## **Application by RWE Renewables UK Solar and Storage Limited for Peartree Hill Solar Farm (EN010157)**

### **The Examining Authority's (ExA's) written questions and requests for information (ExQ1)**

**Issued on 29 July 2025**

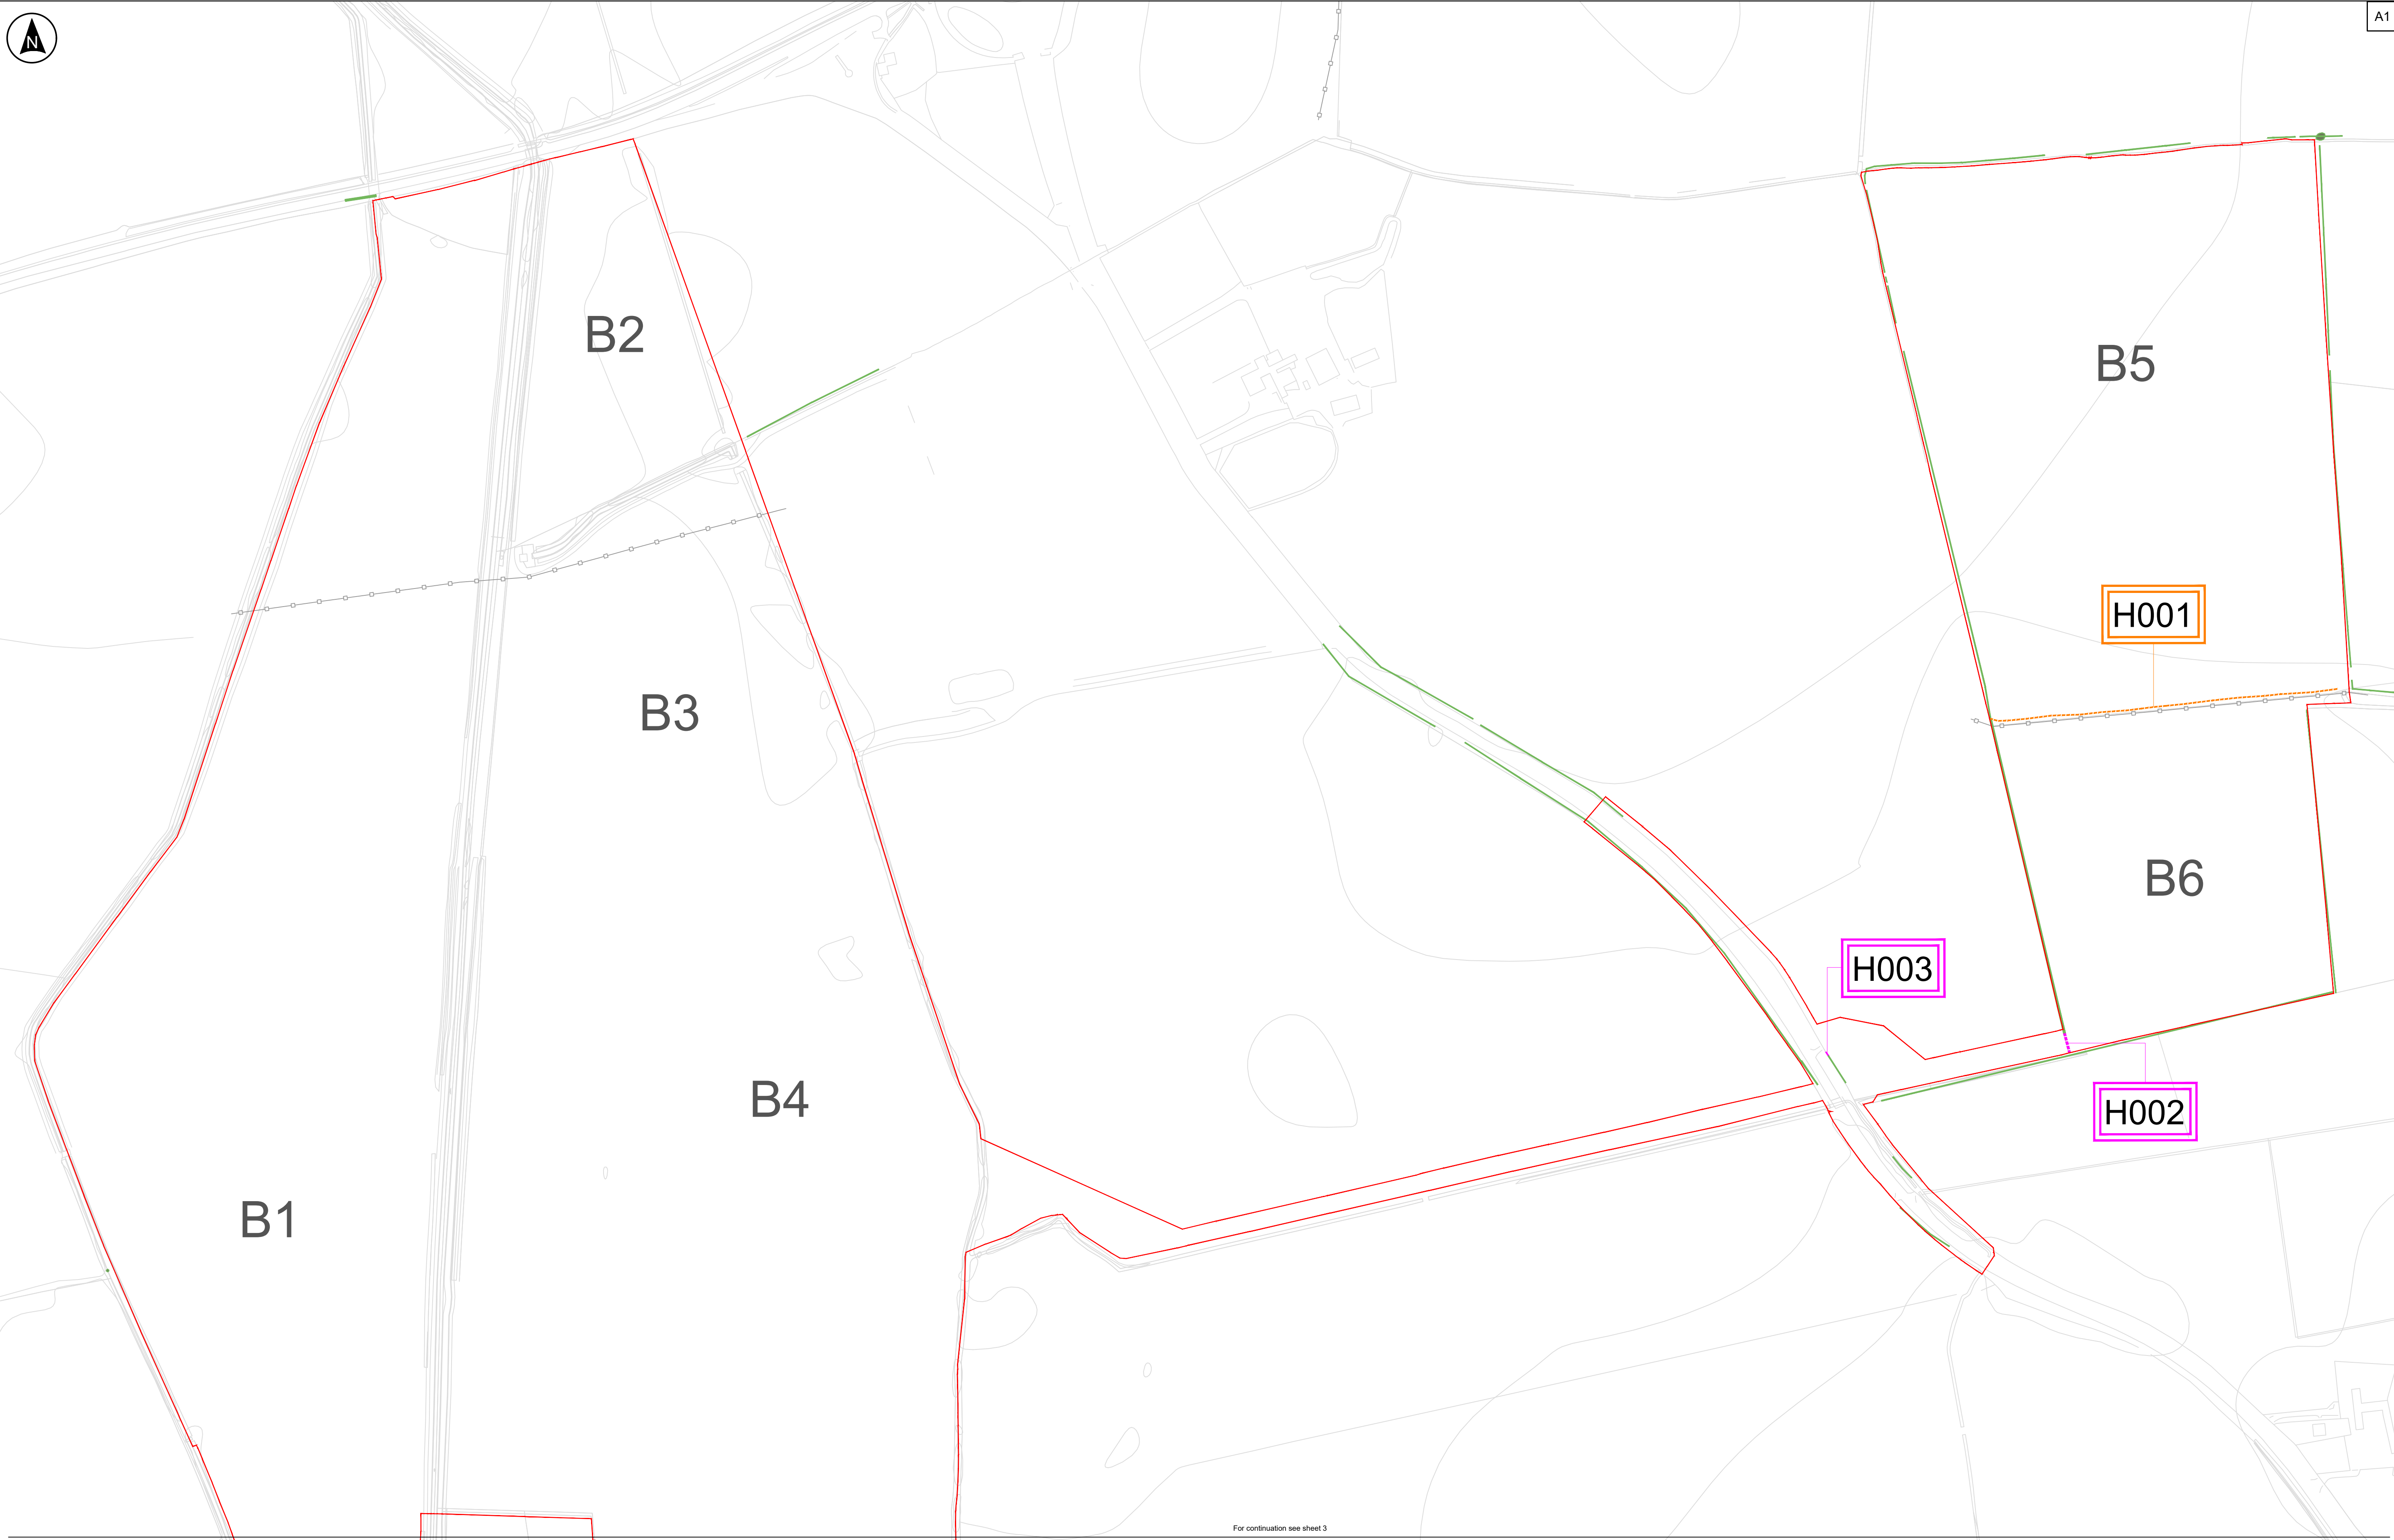
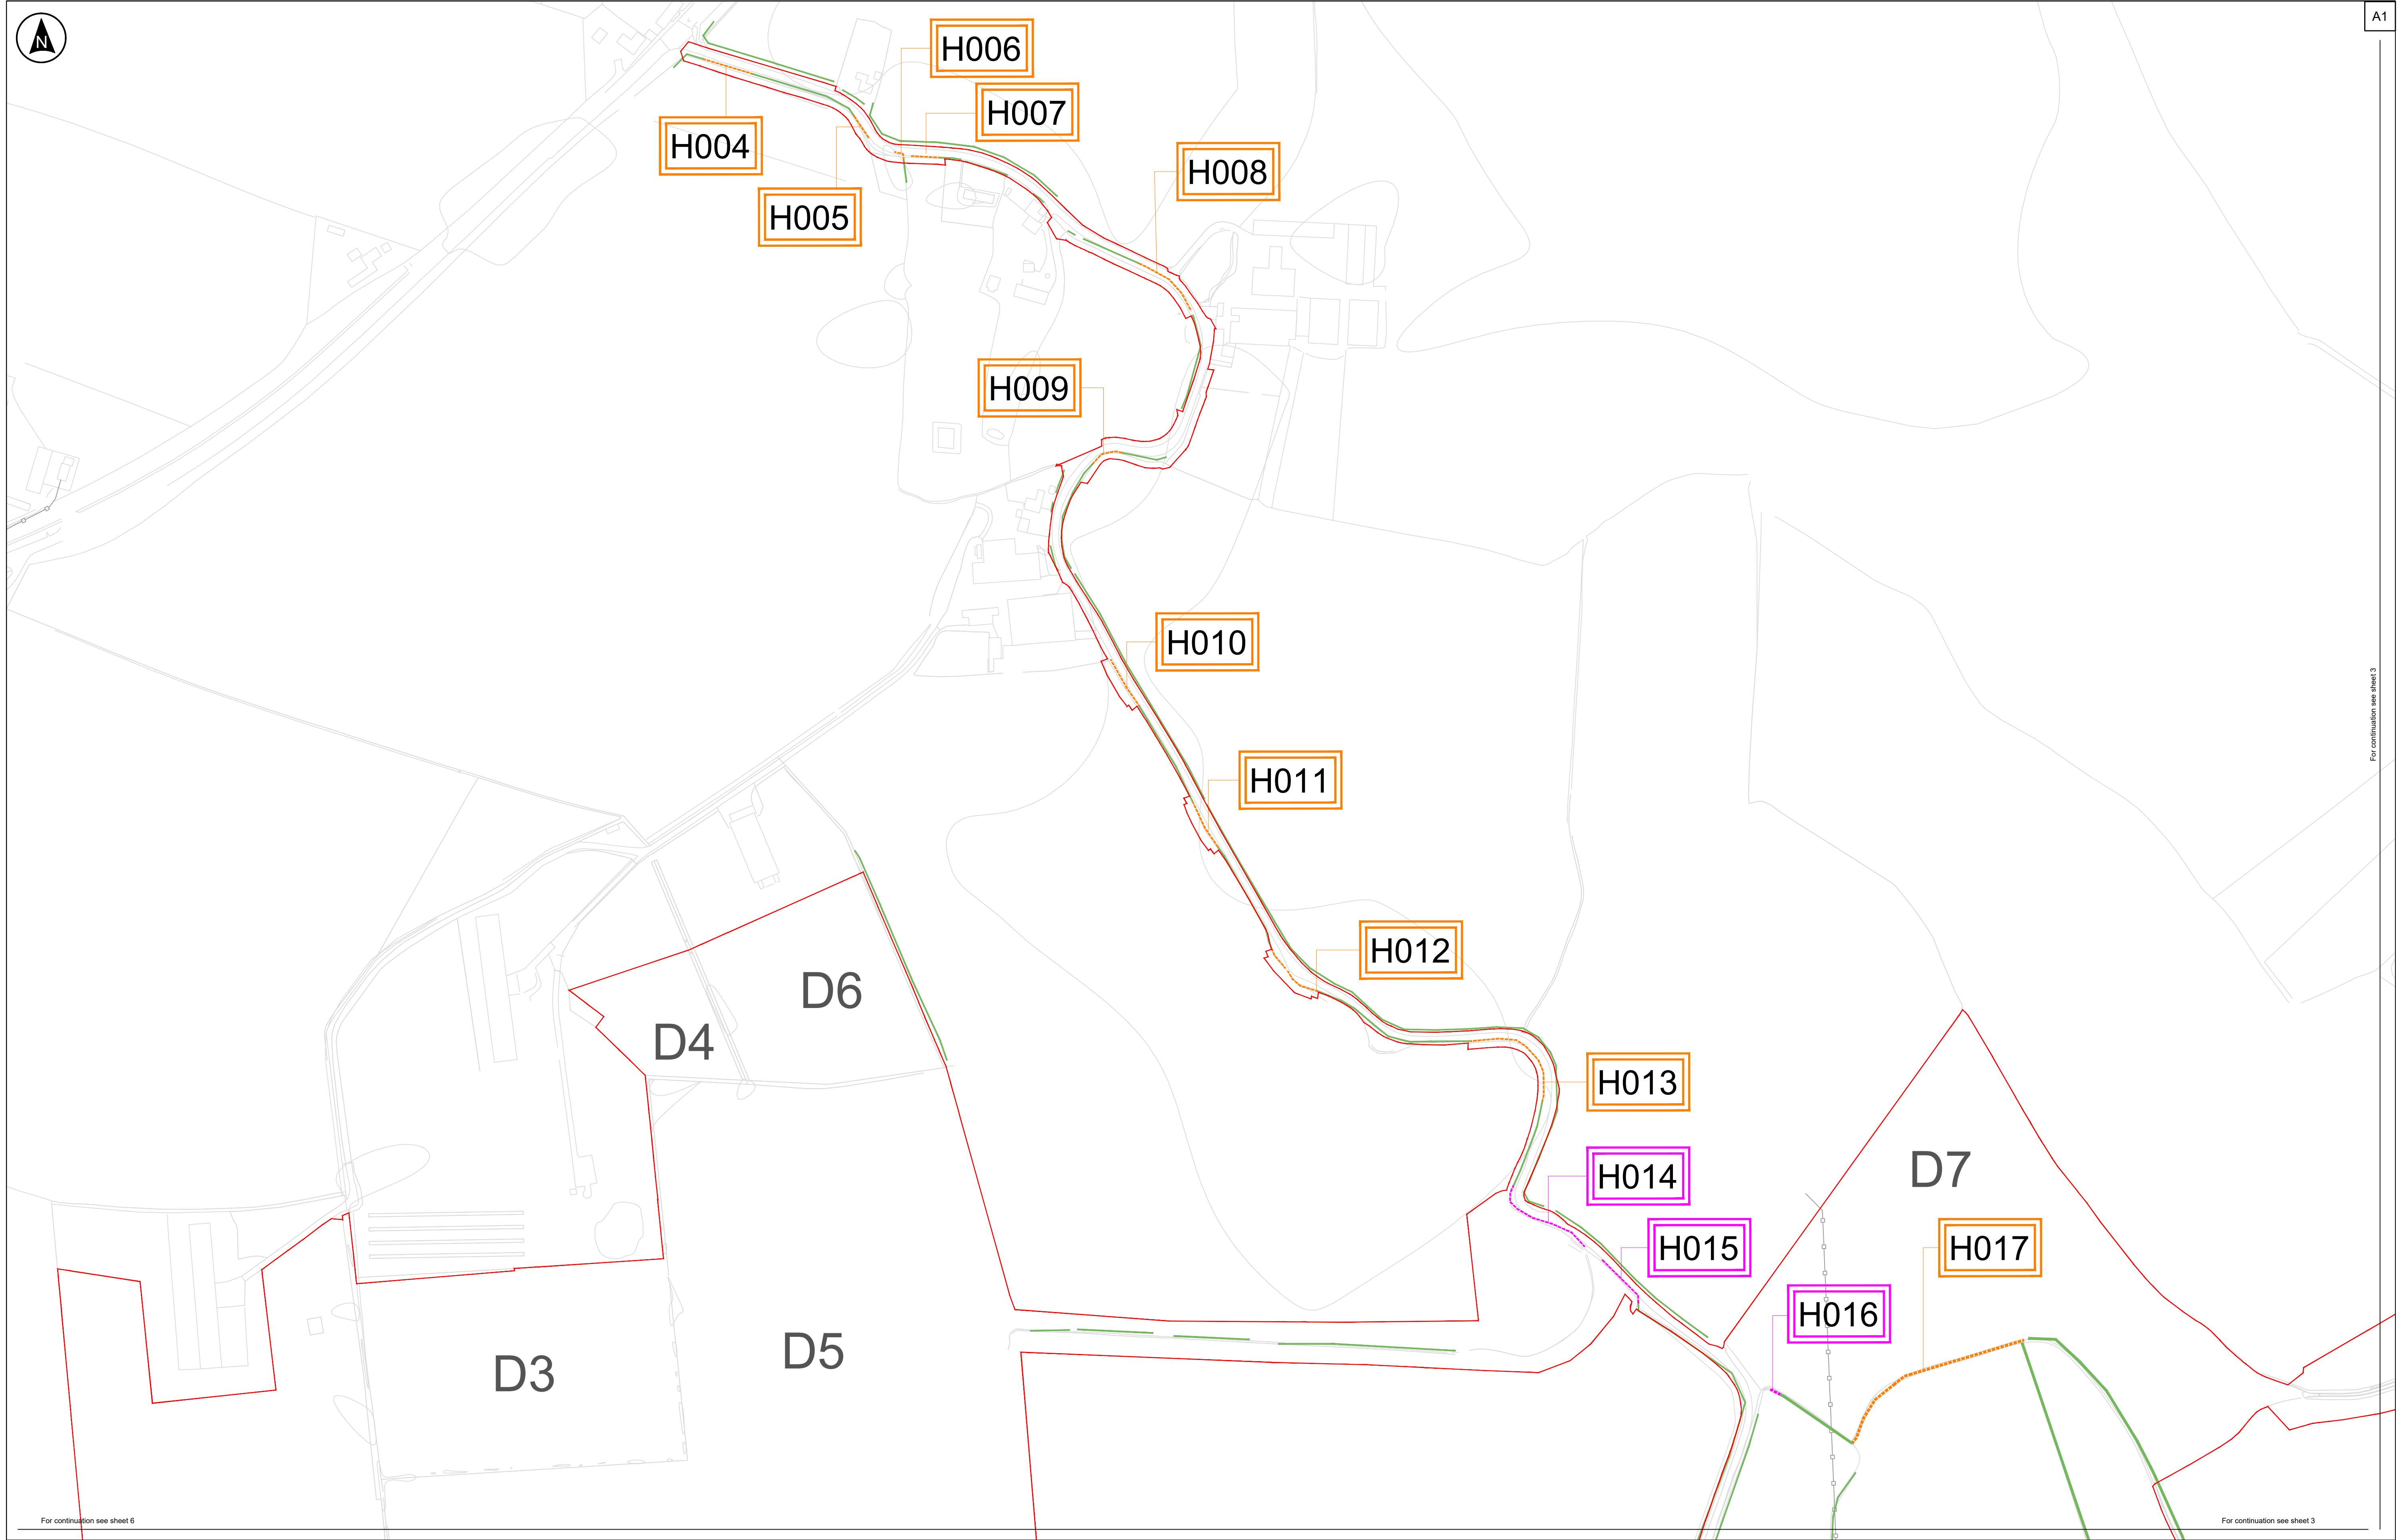
1.2.74	The applicant	Sch 13, Part 2 – some hedgerows appear to be incorrectly numbered with an additional zero (including H0014, H0015, H0016, H0024 and H0043) when compared with the relevant plan [PDA-007]. Please address as necessary
